Recommendation Report for Planning Permission for Works or Extension to a Dwelling

REF NO: M/6/19/HH

LOCATION: 24 West Drive
Middleton on Sea
PO22 7TS

PROPOSAL: First floor front extension & external stair to balcony

PROPOSED PLANS AND ELEVATIONS
SITE PLAN.

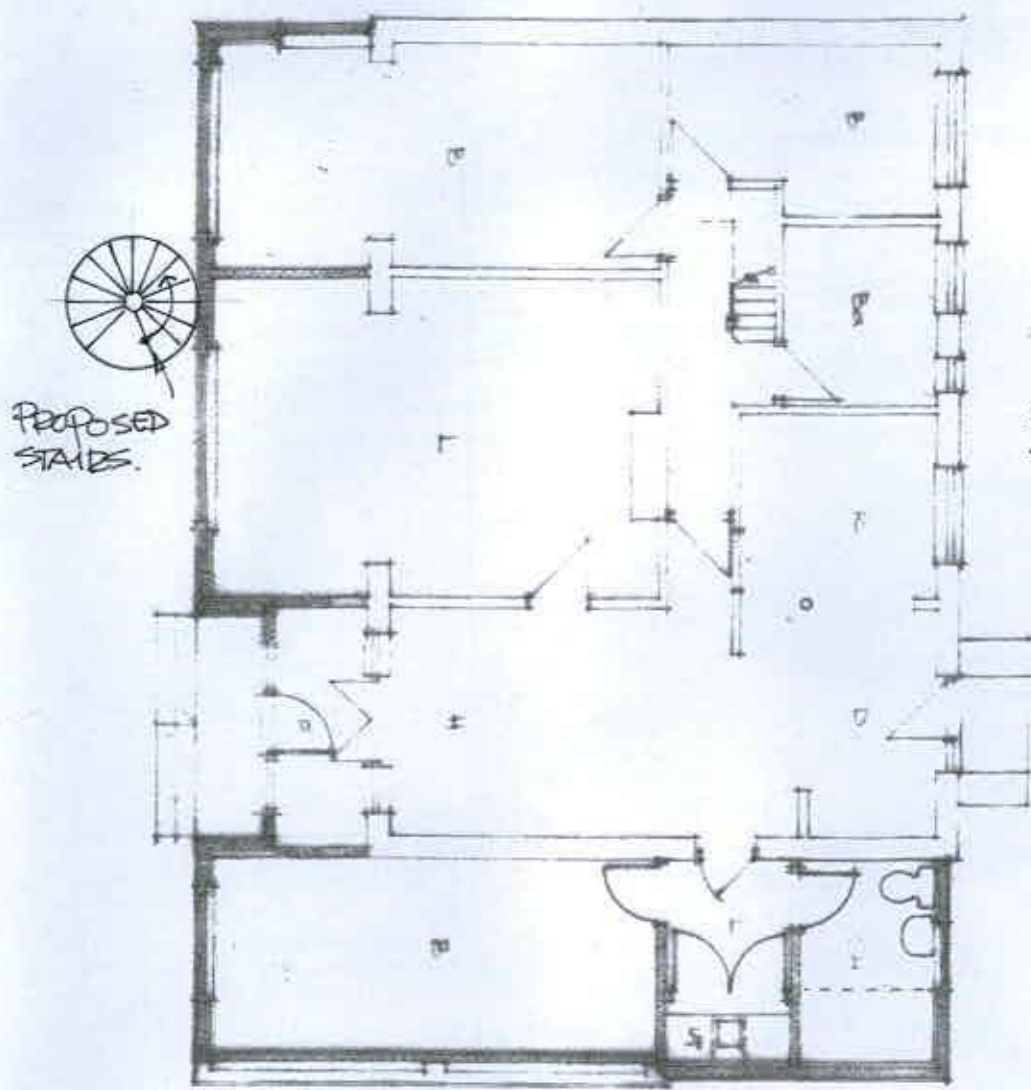
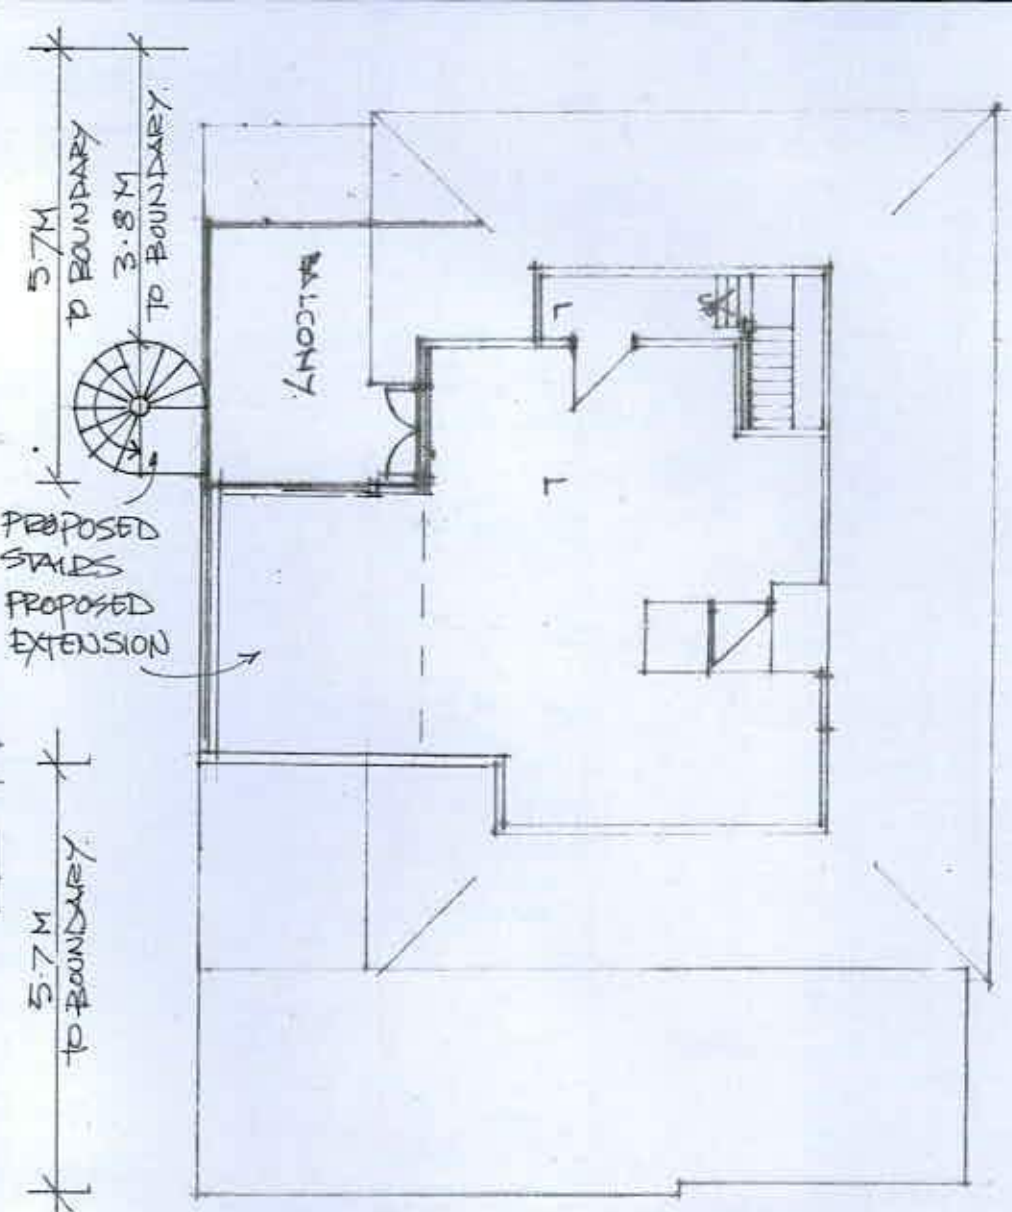
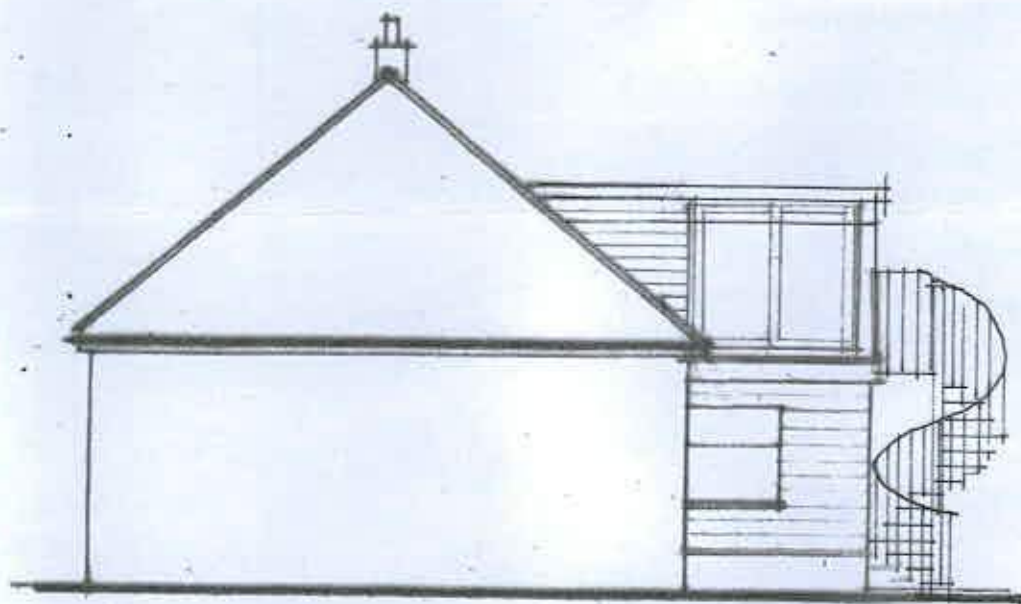
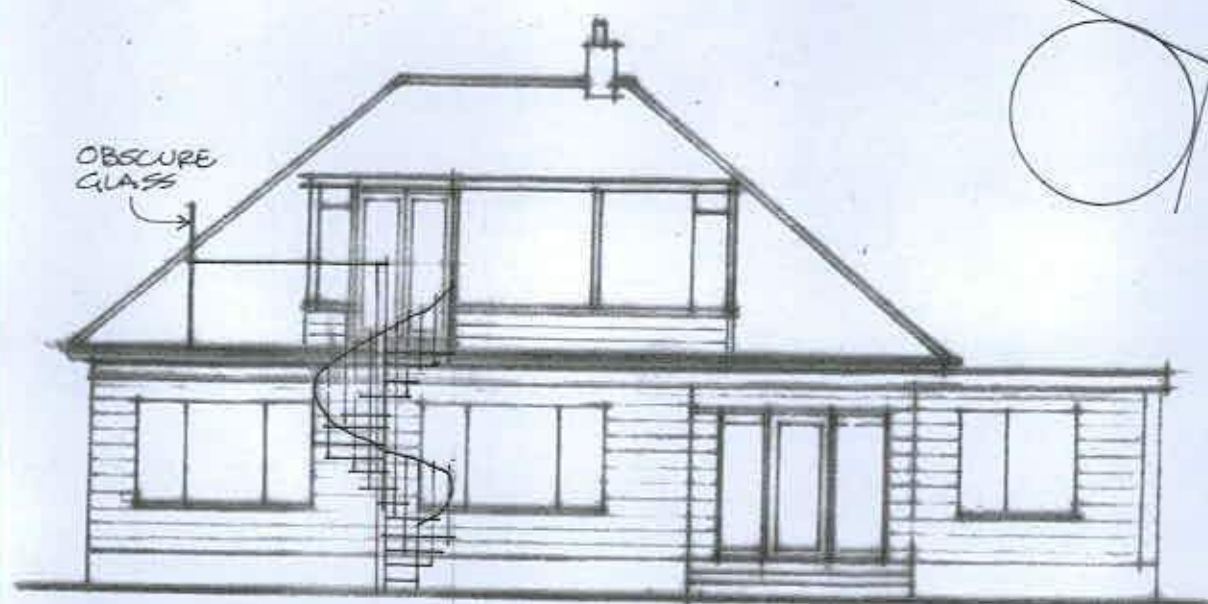
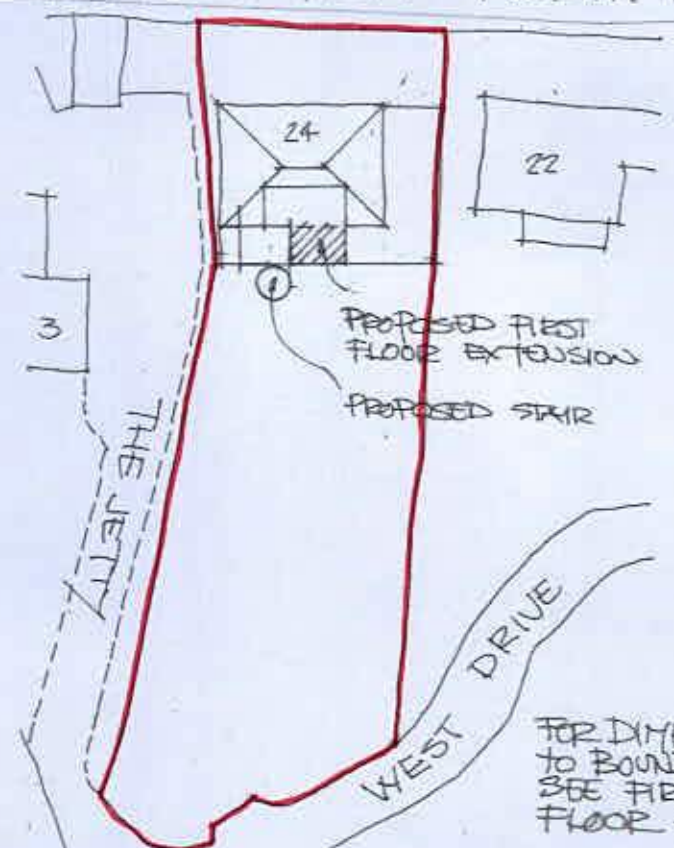
- 4 The balcony element hereby approved shall not be bought in to use until the 1.8m obscure glazed screen has been erected on the Southern aspect of the balcony. The screen shall be maintained in perpetuity unless otherwise agreed in writing by the Local Planning Authority.

SIDE ELEVATION - NORTH 1:100

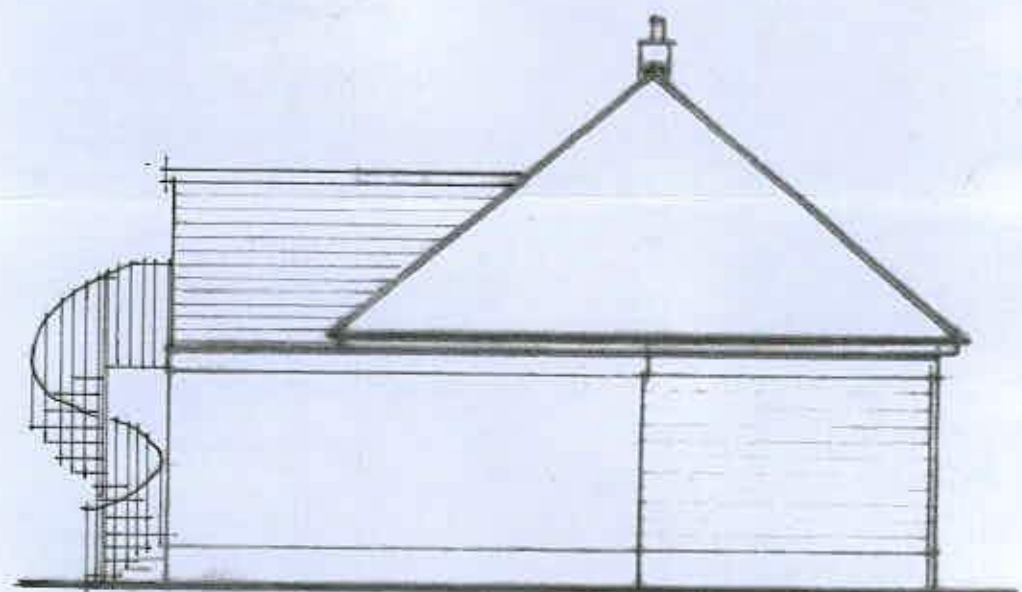
The proposal is not deemed to have a significant overshadowing or overbearing impact on adjacent properties, due to its relatively modest scale and siting on the host dwelling. The proposed development features no windows on its Northern elevation, and therefore is not considered to provide any views that result in a loss of privacy to occupiers of adjacent dwellings. There is an obscure glazing screen on the
